**To:** Elizabeth Boepple, Chair, and Members of the Portland Planning Board  
**From:** Nell Donaldson, Planner  
**Date:** October 25, 2016  
**Re:** **Addendum to Planning Board Report for Project # 2016-120 – 23 Ocean Avenue**

Following are revised proposed motions for the Level III site plan and subdivision review for the mixed use development at 23 Ocean Avenue. The conditions of approval have been revised to reflect additional public comments and responses from the applicant.

3 SIDEWALK RAMP DETECTABLE WARNING TILE AND APEX RAMP
NOT TO SCALE

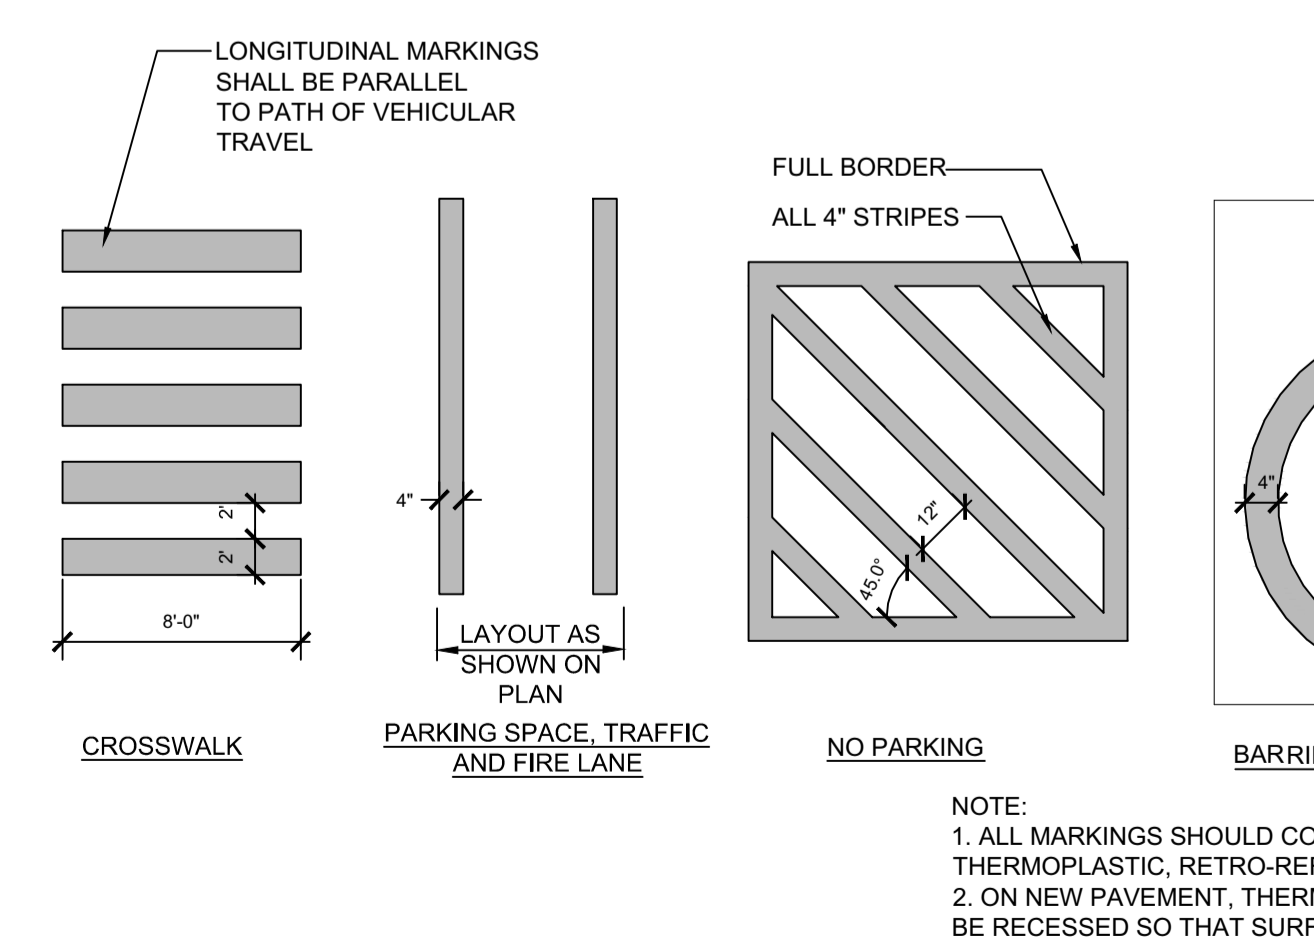
- d) Construction phasing;
2. The applicant shall submit final details for the reconstruction of the ramp on the south side of Hersey Street to meet ADA requirements for review and approval by the Department of Public Works;
